**Brett's Aggregates Ltd (Brett)
&
Esso London to Southampton Pipeline**

**Representation 1 – Brett Planning Permission to Extract Sand & Gravel from
Manor Farm and Convey beneath Ashford Road into Queen Mary Quarry,
Ashford Road, Staines**

Drawing number:
B2325300-JAC-000-ENV-DRG-111169

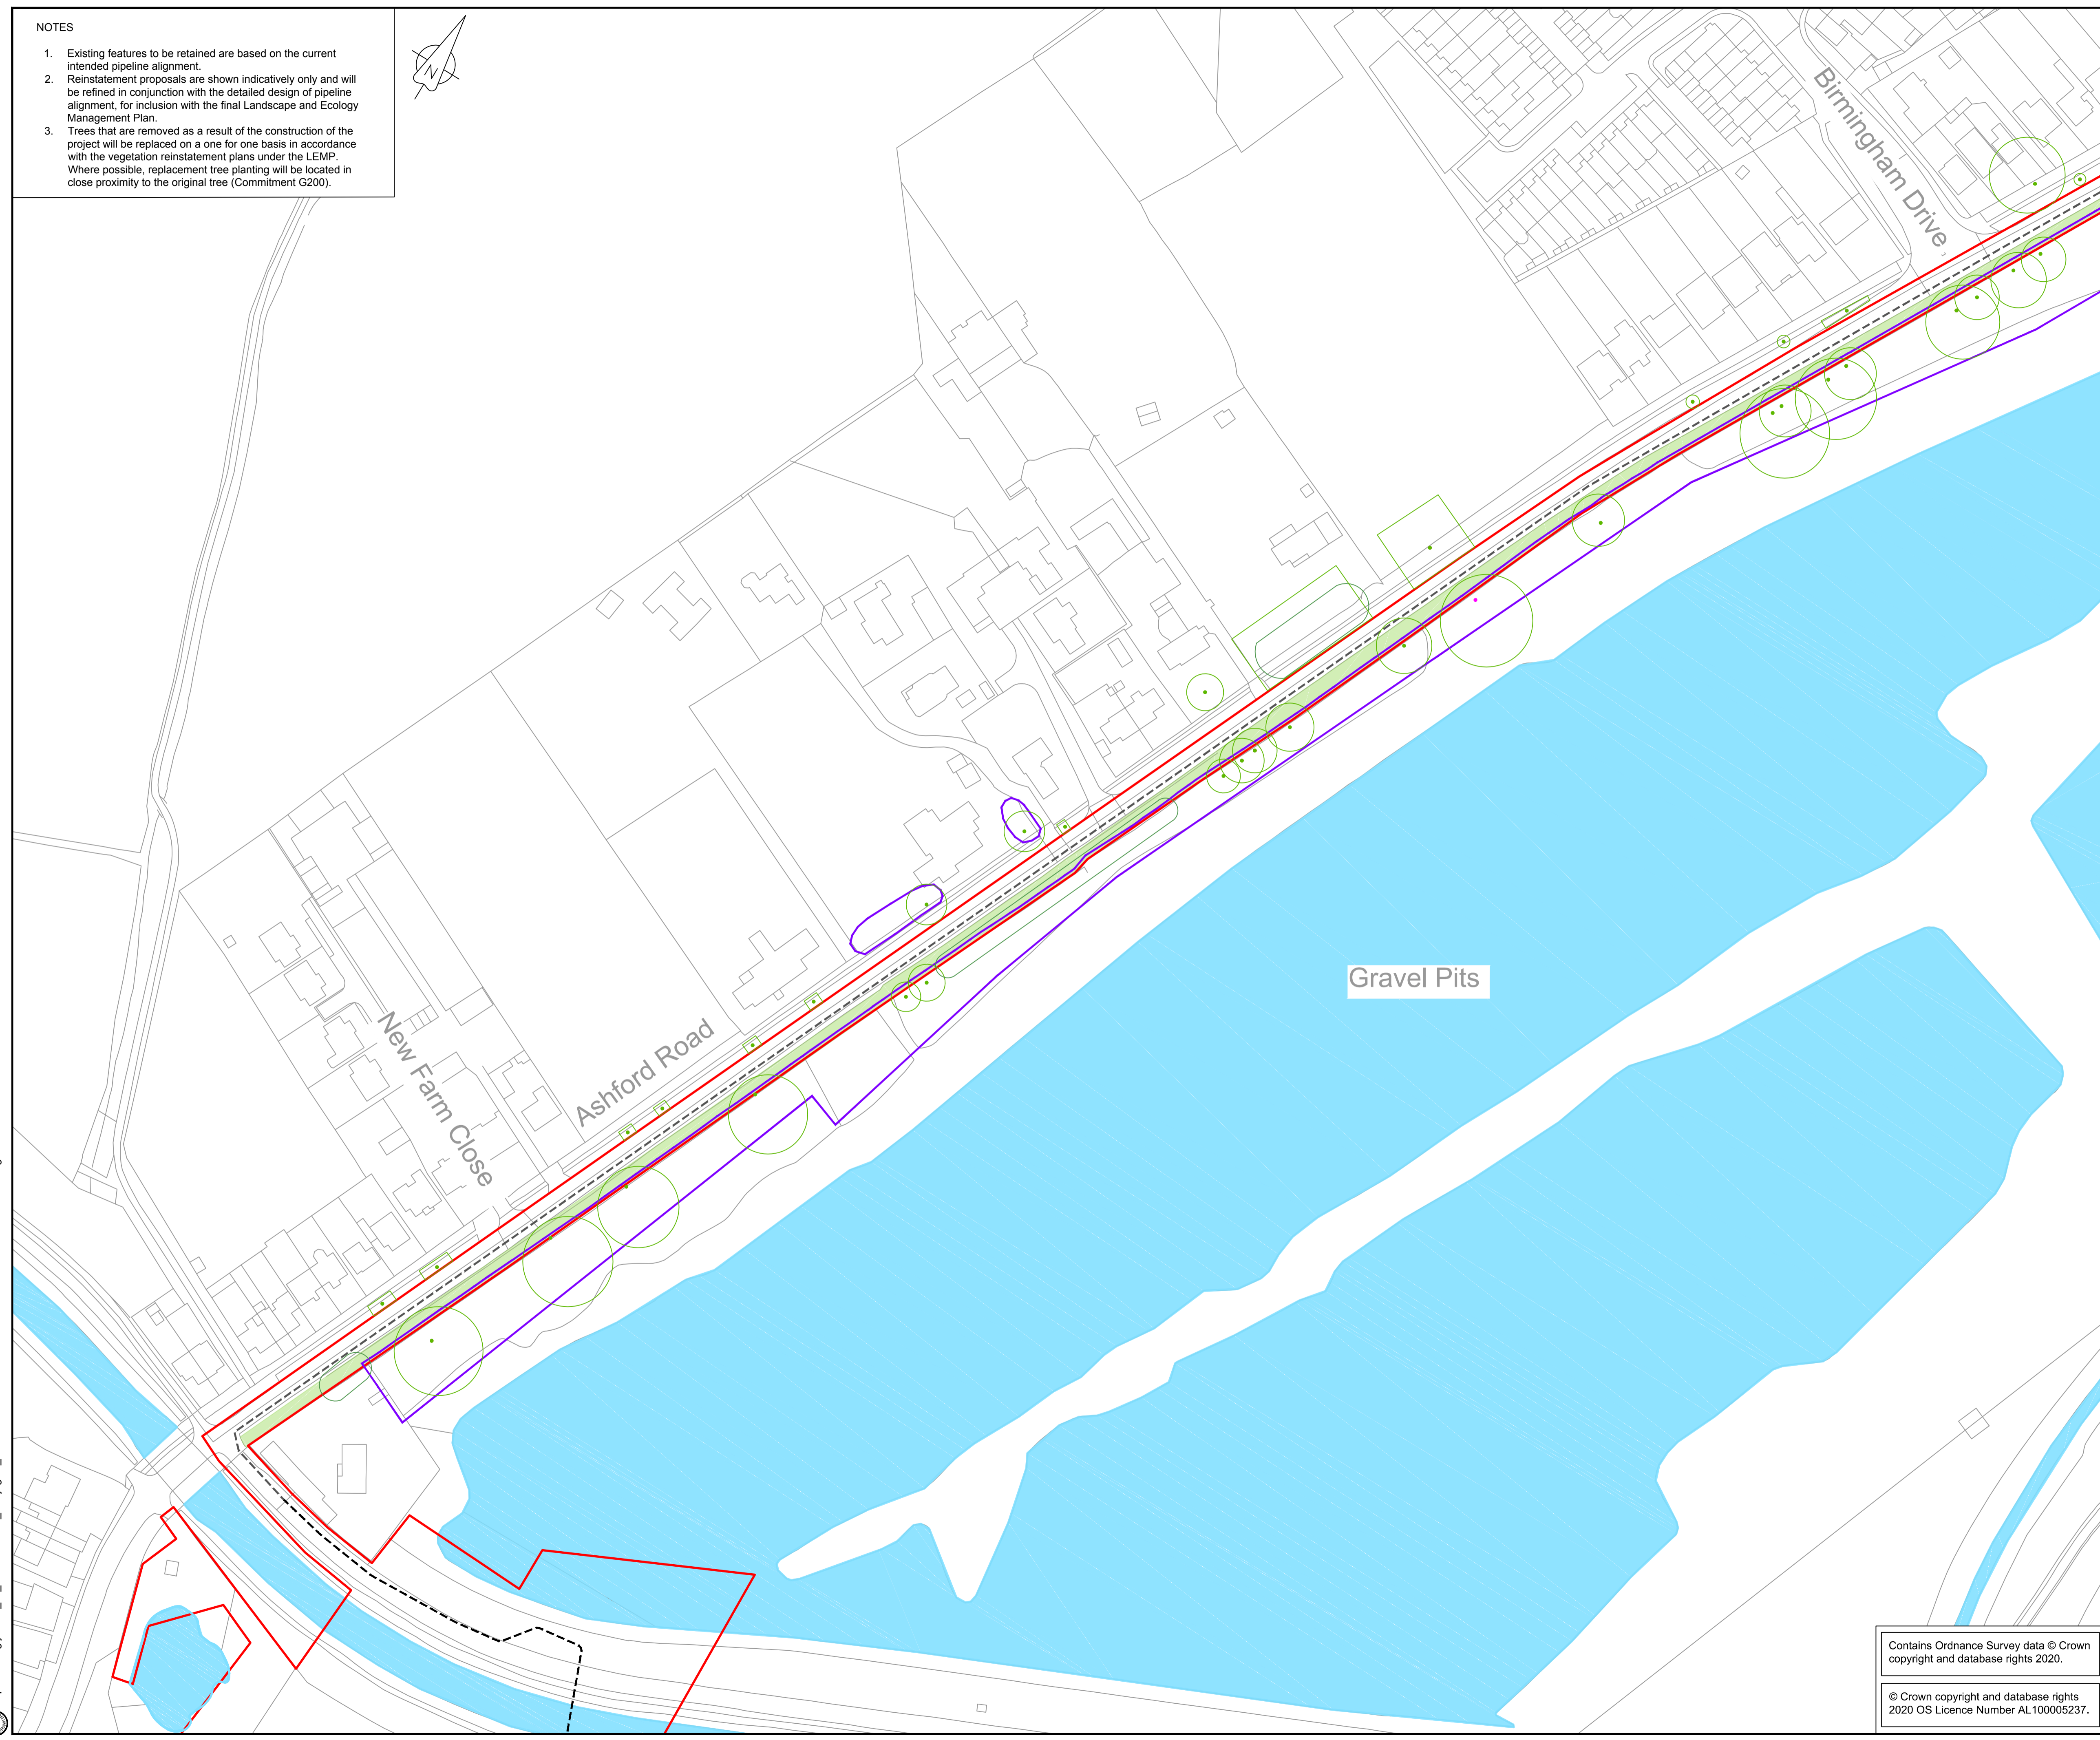
- The general arrangement of the proposed tunnel will run directly beneath the proposed Esso fuel pipeline.
- There is no apparent provision made by Esso for the installation of the conveyor belt tunnel once the proposed fuel pipeline has been put in place along this section of the B377 Ashford Road.

- The installation of the new conveyor belt tunnel is not planned until extraction from Manor Farm commences. It is understood that Esso require to install their new fuel pipeline in the next 2 years. It is essential that the Esso pipeline does not hamper Brett when they come to install their conveyor tunnel. Their DCO application does not demonstrate how this will be achieved.

- Given that Brett have secured all the legal rights to install its proposed conveyor tunnel, prior to Esso's fuel pipeline being proposed, we require Esso to make provision for the installation of the Brett tunnel by entering into a legal agreement ensuring Brett's rights are fully maintained in the future and so not to prevent the abstraction of minerals from this site
